Approval of details reserved by condition imposed under AL/136/17/PL relating to Condition No 3 - surface water drainage.

Land West of Fontwell Avenue 1 Fontwell Avenue PO20 3RU

Arun District Council have decided to **REFUSE details reserved by condition for the following reasons:**

Client	Mr David Parker
Drawing Title	Surface Water Drainage

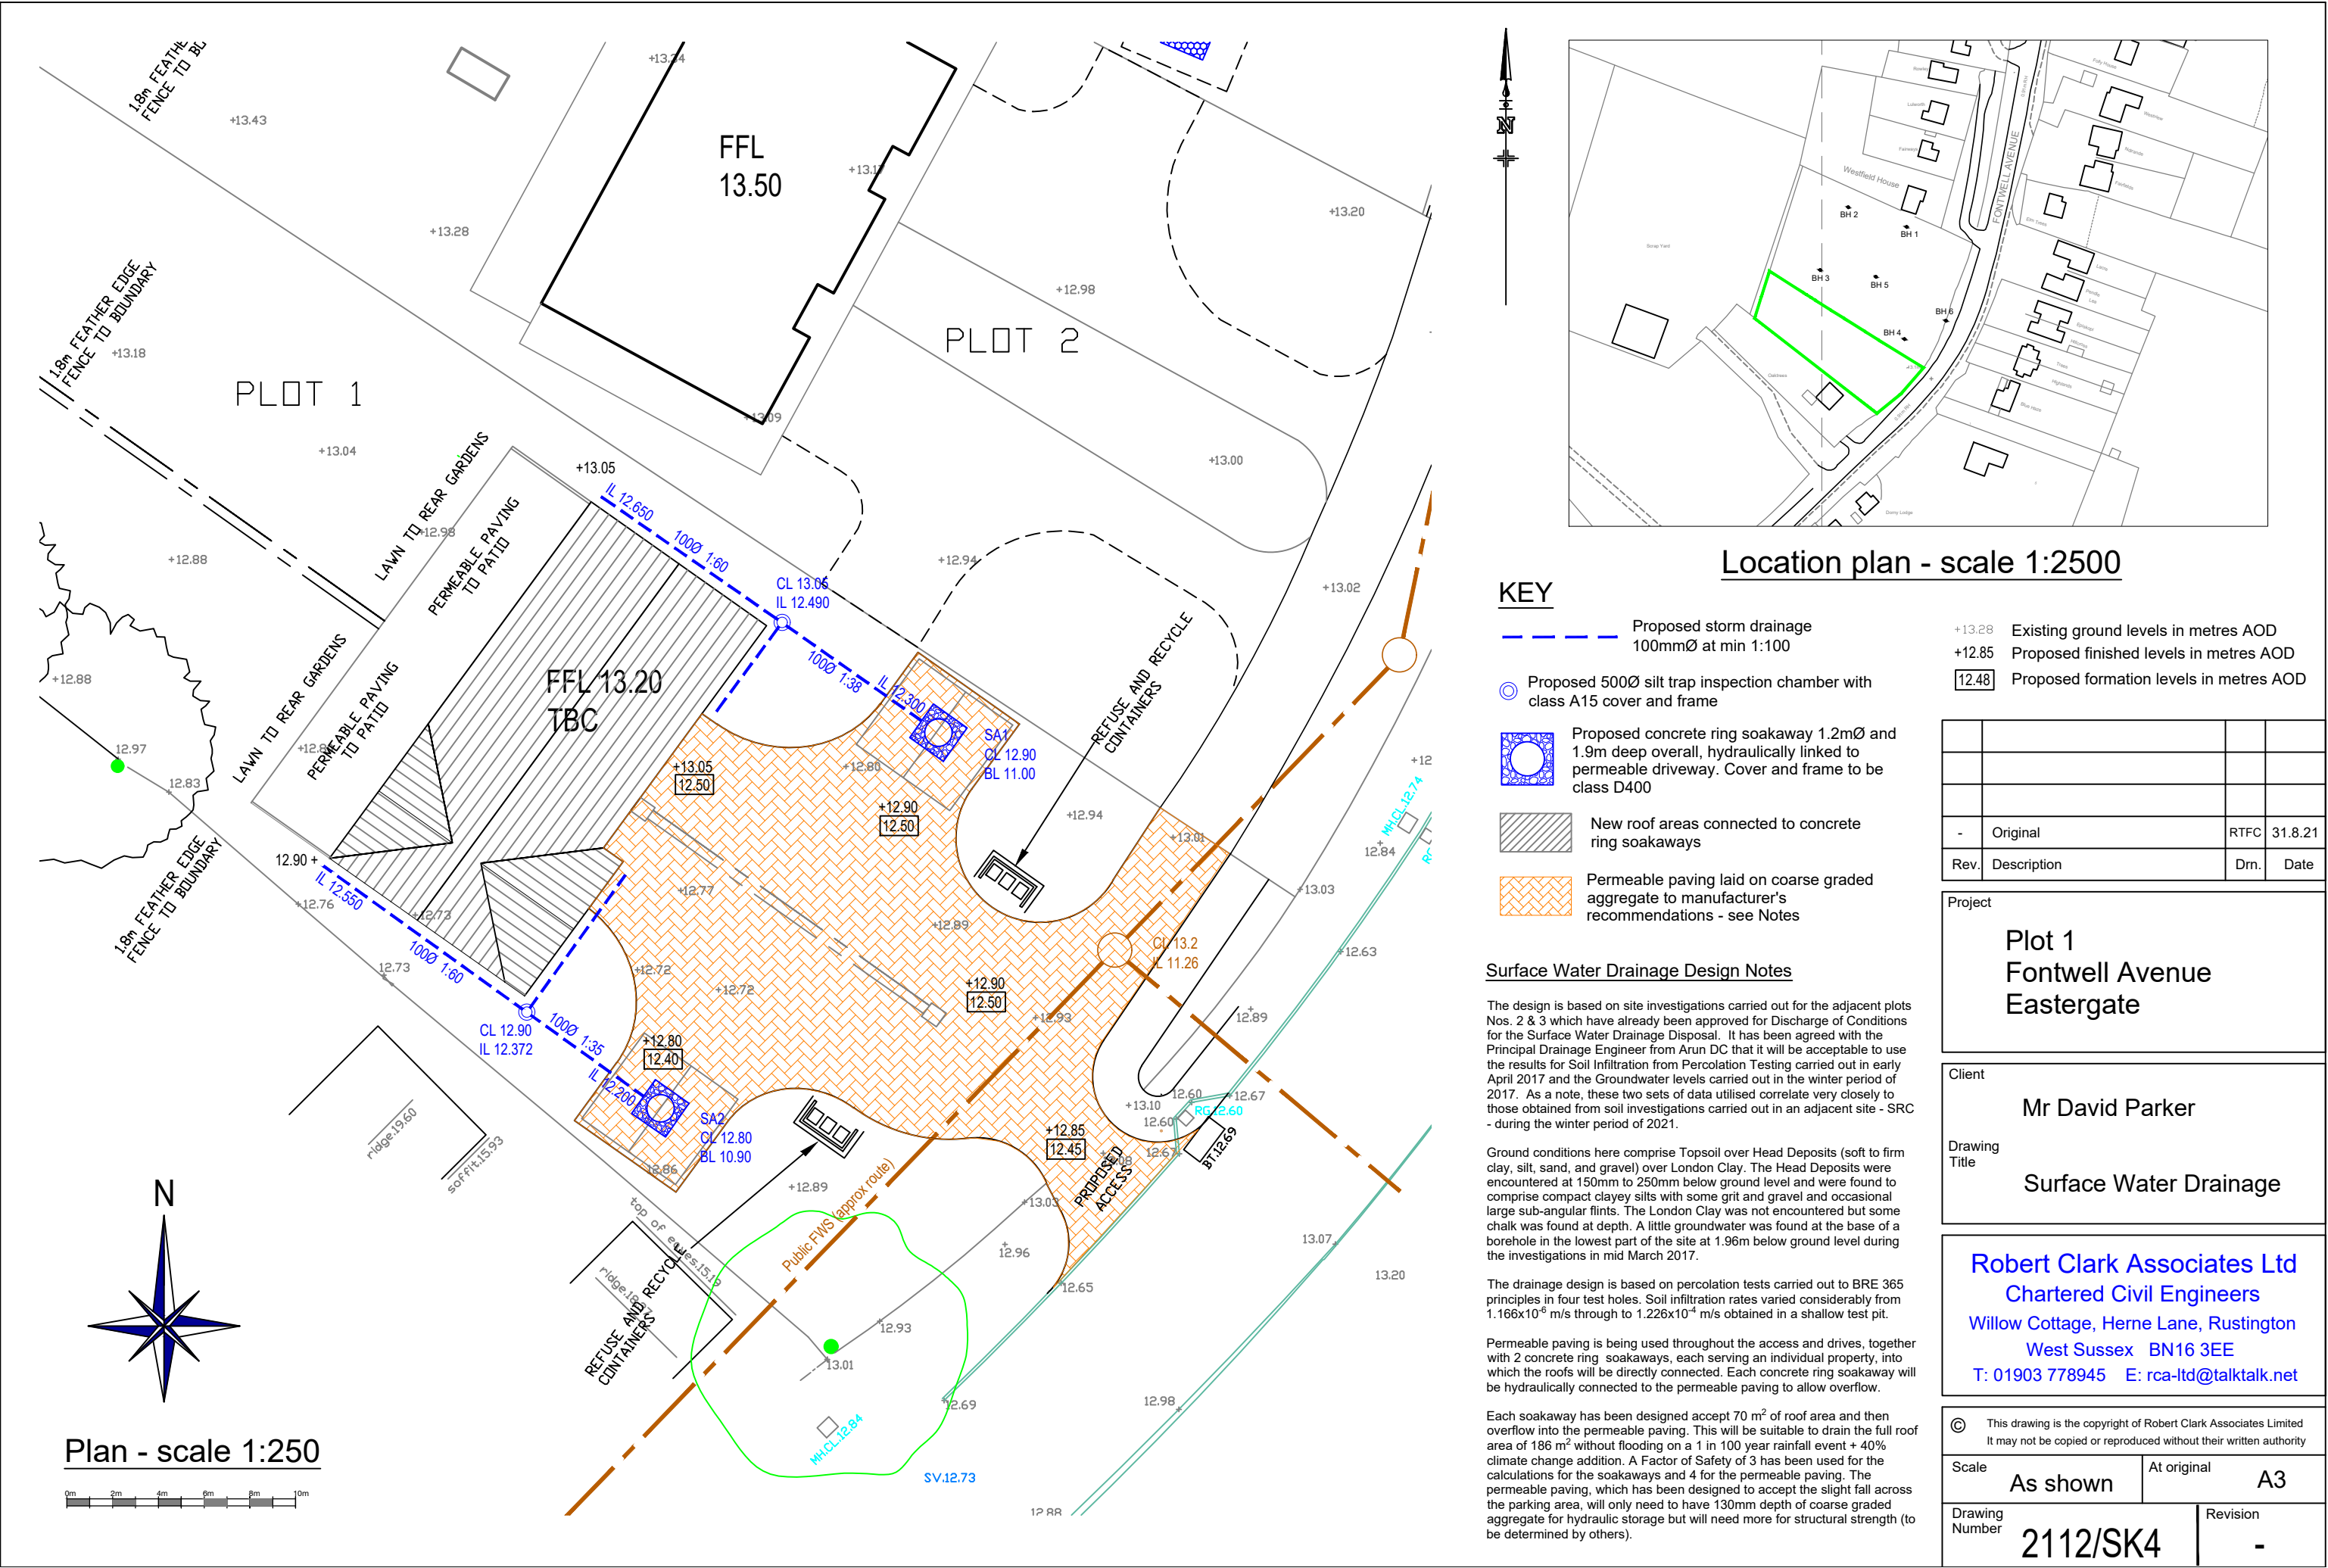
The Council's Drainage Engineers did not recommend discharge of condition 3 (Please see Engineers Comments Regarding Condition 3 from 2nd November 2021 and 13th October 2021). A design based on infiltration testing completed outside of winter and ignoring worst case results are not acceptable.
